From: Gemma Bennett
Sent: Tuesday, 23 October 2018 9:35 AM
To: Bianca Thornton
Cc: Simone Muscat
Subject: RE: Notification - Sigma Pharmaceutical Warehouse and Distribution Facility (SSD 7719 MOD 2)

Response to modification application for the Oakdale South Industrial Estate at Kemps Creek (SSD 6917 MOD 7 & SSD 7719 MOD 1)

Drawing Name:
Landscape Plan

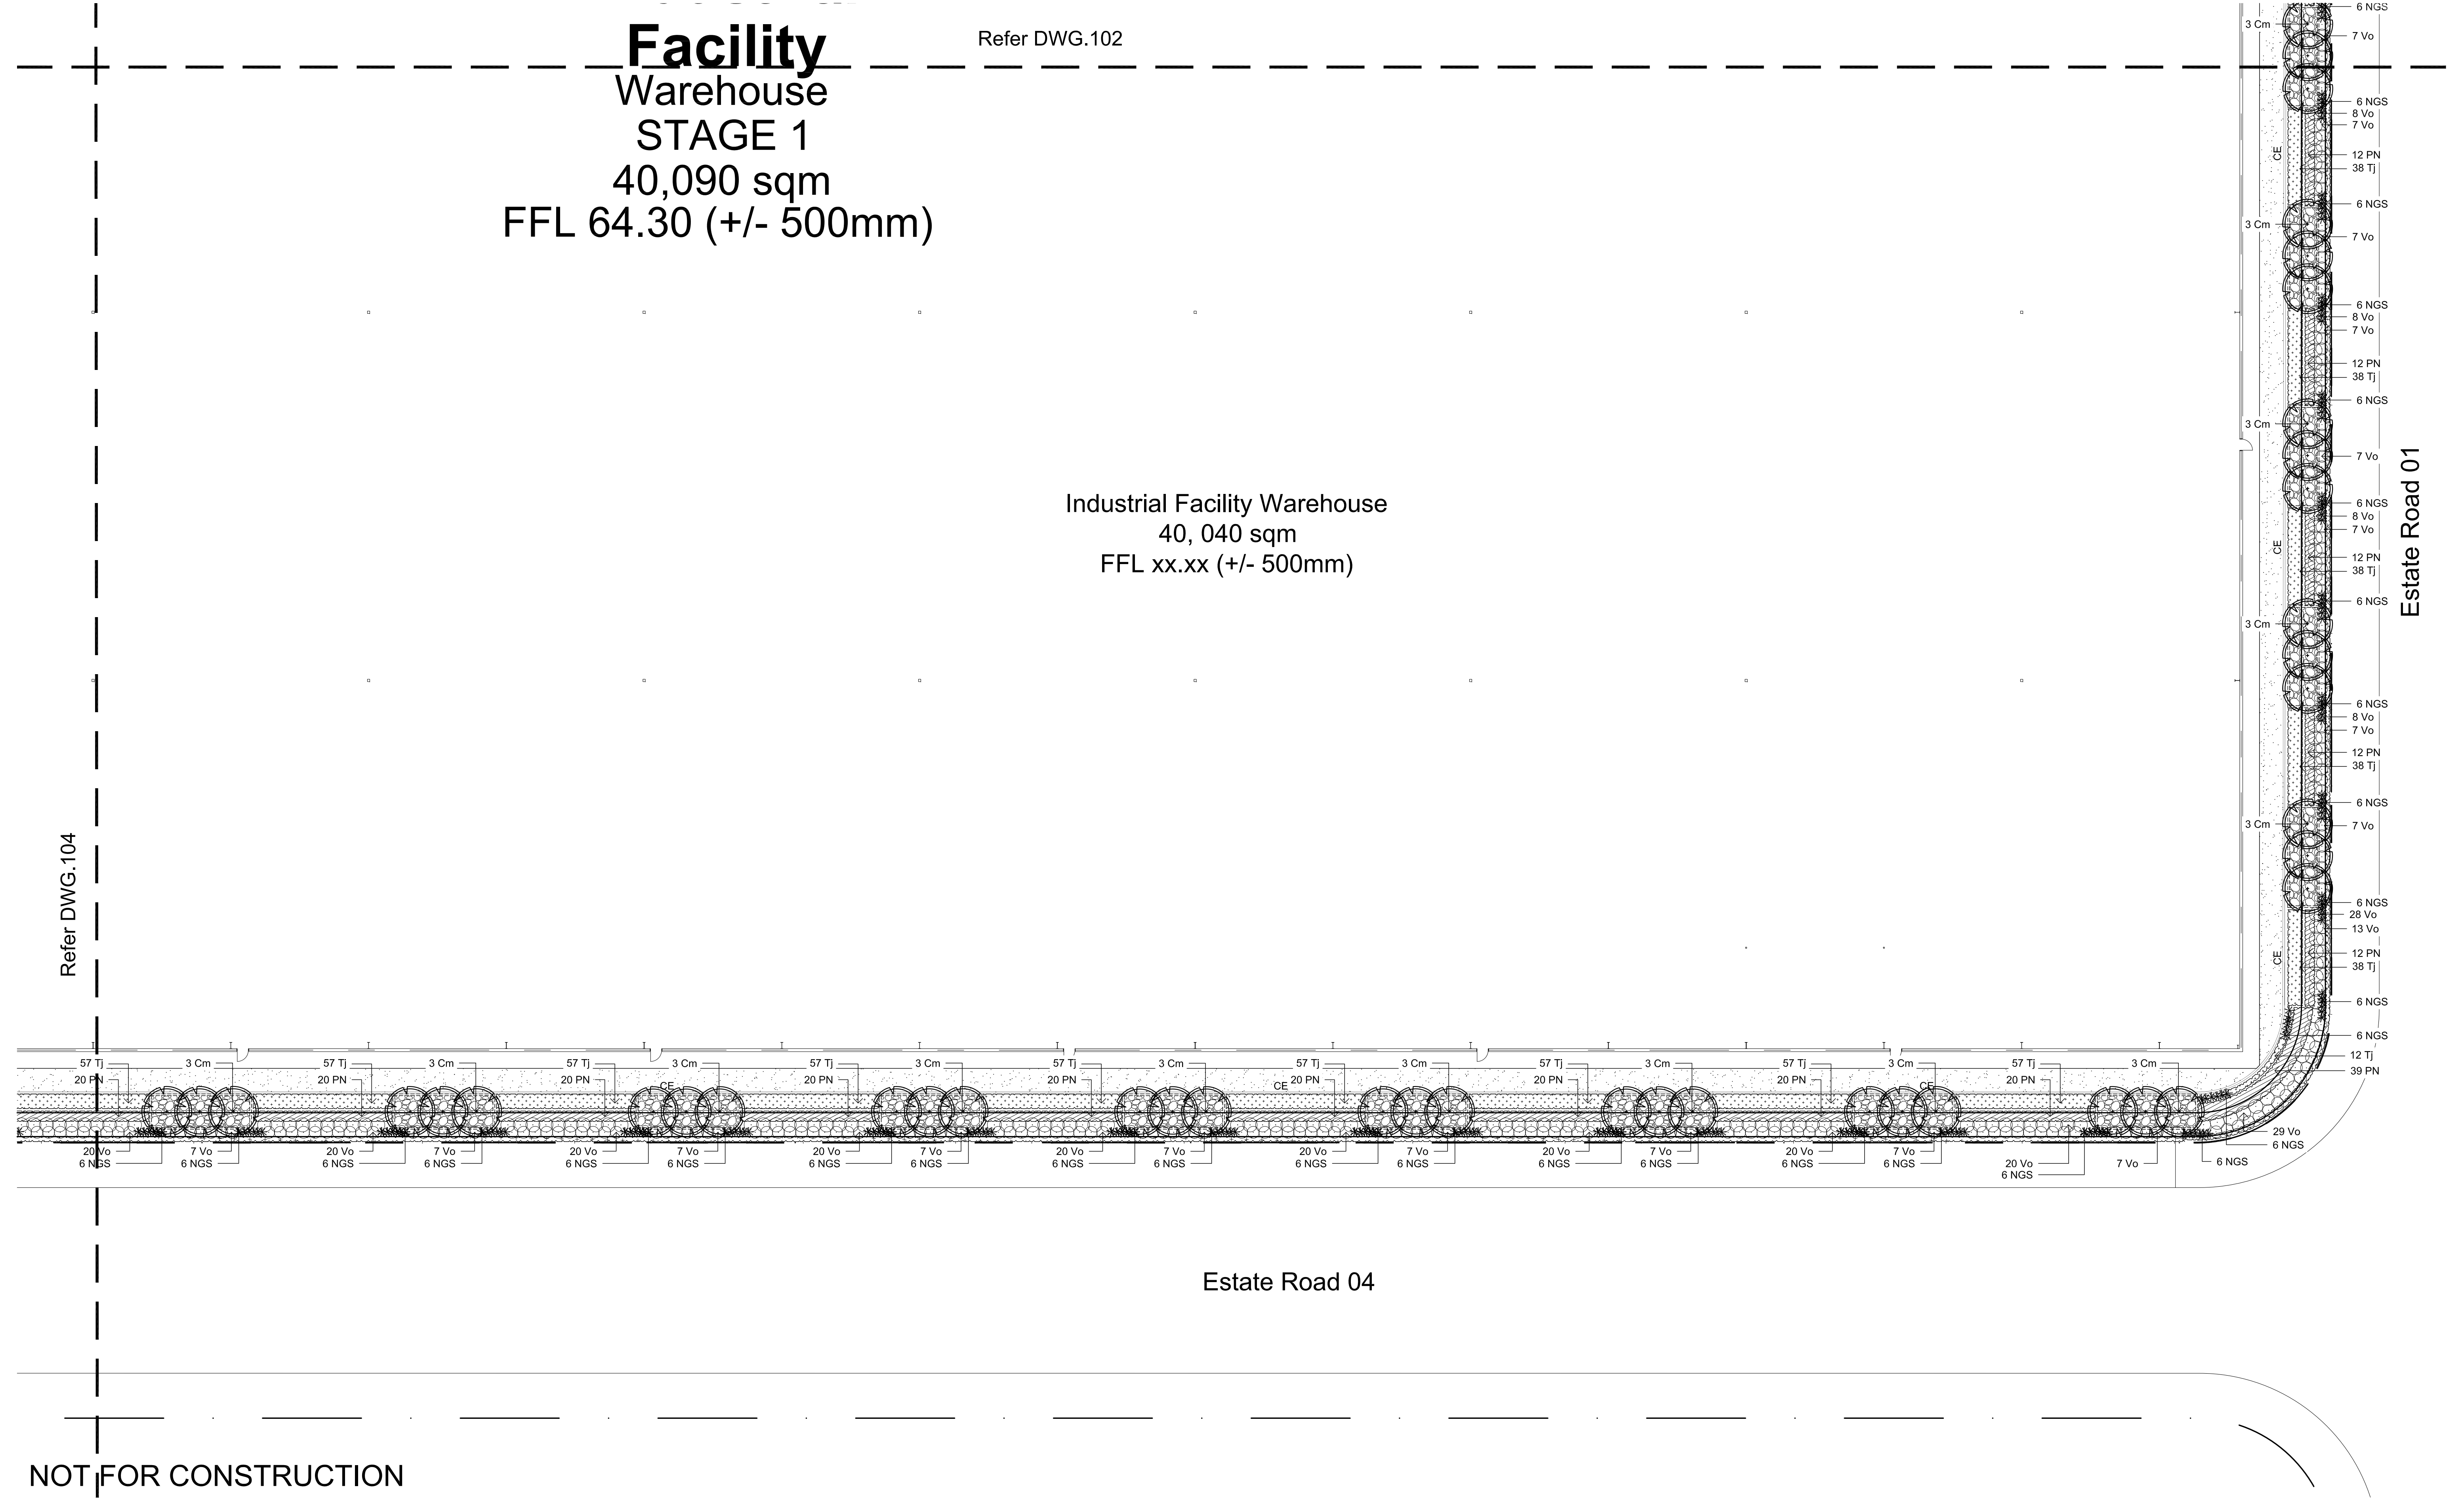
While the rezoning may be appropriate given the approved road configurations, the proposed extent of additional hard stand area now proposed is not considered to be appropriate at this intersection and an improved landscape setback between the property boundary and car parking areas should be required.

The proposed plans provide for a 2.5m setback to Road 06 which is inadequate given the location of this site. The corner of the site (south east) requires an embellished landscape setback to frame the intersection of Estate Road 6 and Estate Road 1 which is planned to be embellished to the east and south. The extension of the hard stand out to the intersection area does not suitably respond to the contextual planned landscape character of this intersection, and an increased setback should be provide.

It is also recommended that the access driveway to Estate Road 01 be relocated to Estate Road 6 to provide an unbroken landscape connection along Estate Road 01 for the full width of the lot. This would suitably address the landscape character of this road as well as sites relationship to the E2 zoned land further east. This option may still enable the proposed 2.5m landscape setback to Road 06 further north of the intersection, away from the intersection which is the primary view corridor within the development.

Figure 1 – Comparison of the Landscape Plans for SSD7719

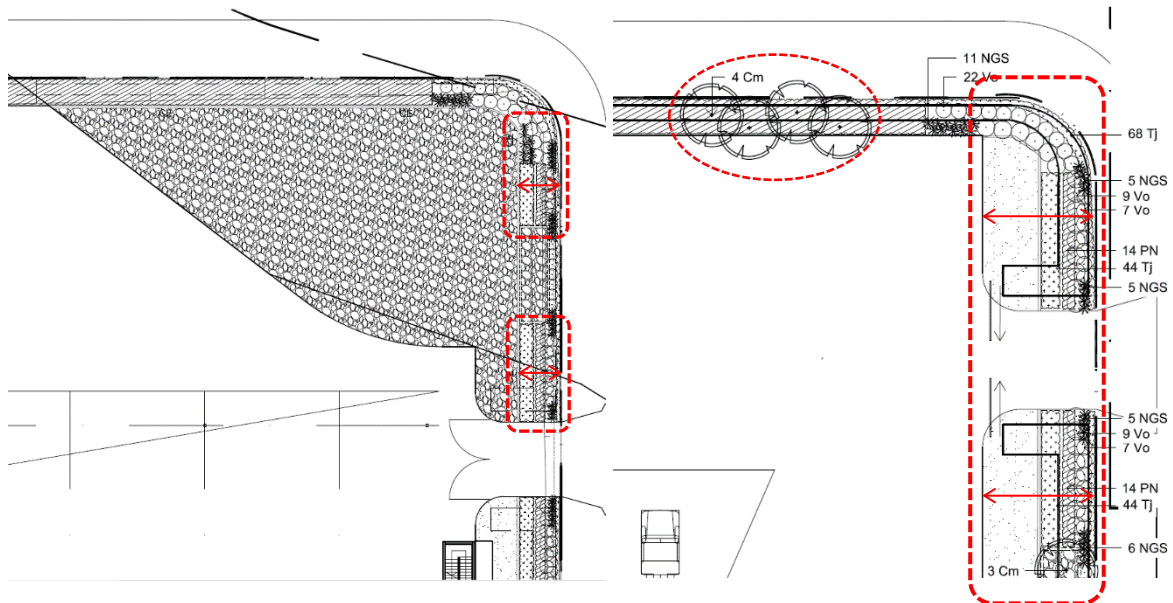
The application submission has been reviewed and Council's comments in regards to landscaping and hard stand areas still apply as detailed in our previous submissions to SSD 7719 and SSD7719 MOD 1.
